Application for a Non-Material Amendment Following a Grant of Planning Permission

22/00957/FUL

The ridge position on the new roof to the one and a half storey section of the property is to move across by approximately 350mm which will make the roof slightly asymmetrical. The ridge height remains as approved and eaves height will be slightly raised to the rear elevation

Drawing Title:  
**Plans and Elevations as Proposed**  
**PLANNING**

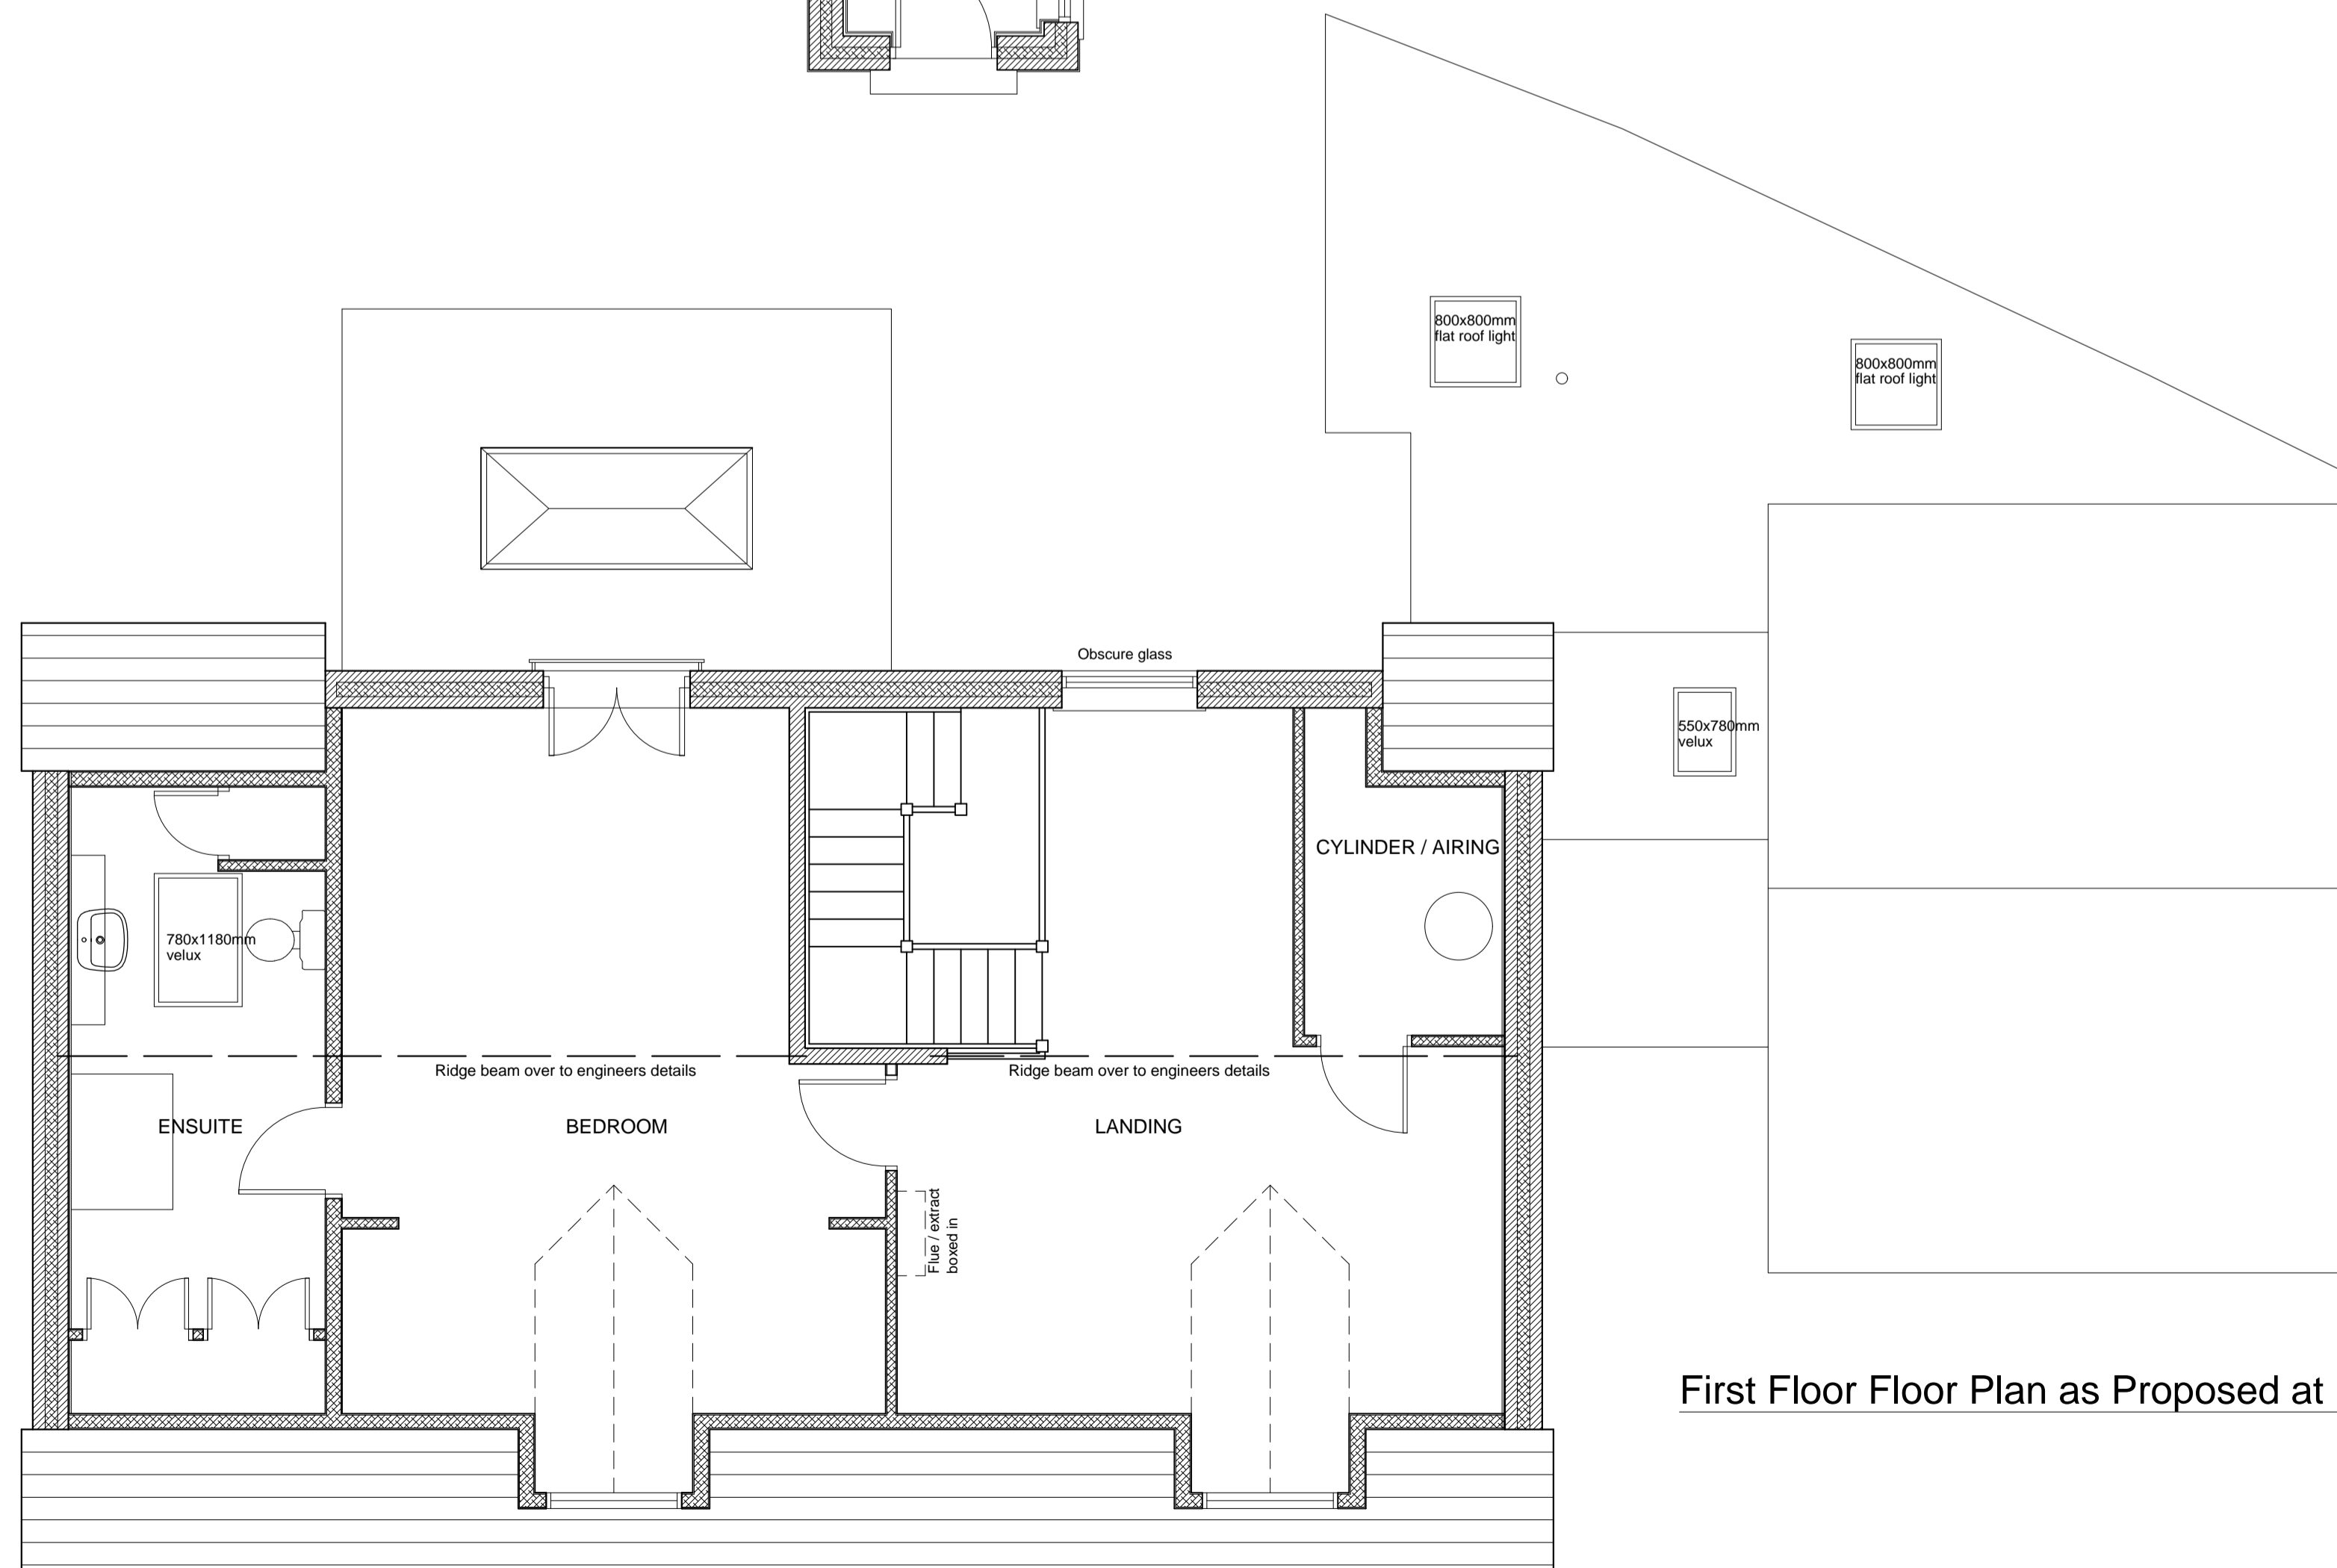
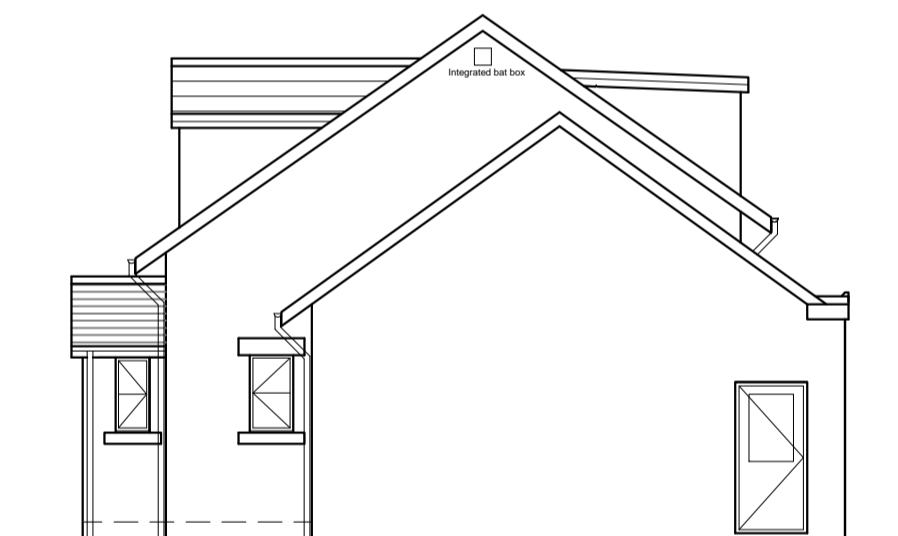
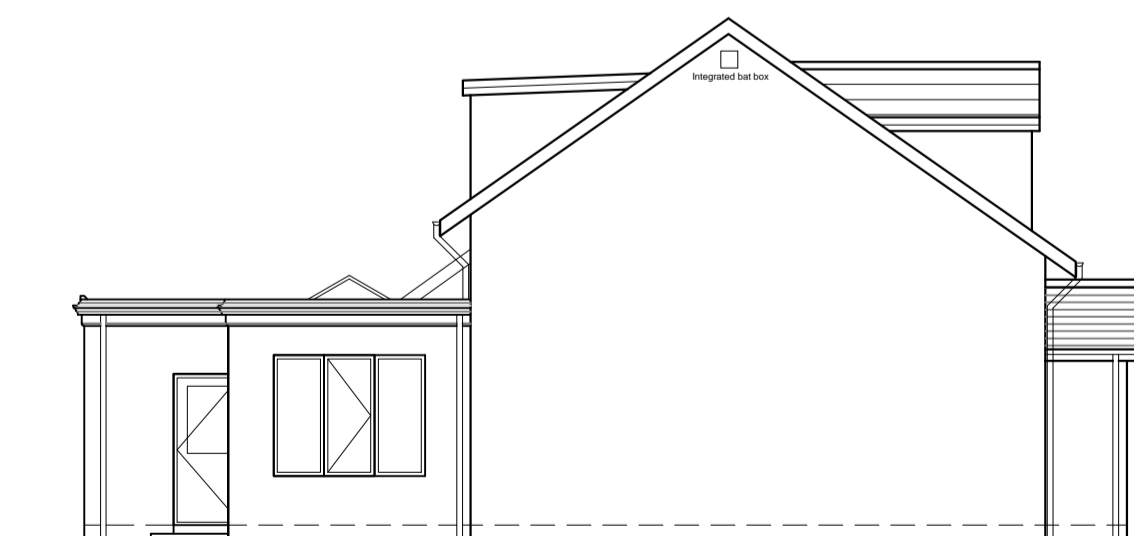
The engineers design shows the requirement for support of the steel ridge beam from the existing solid wall of the stairwell. This wall is slightly off centre and this results in the ridge beam needing to be slightly off centre.

Plans and Elevations as Proposed 22005 / 201D
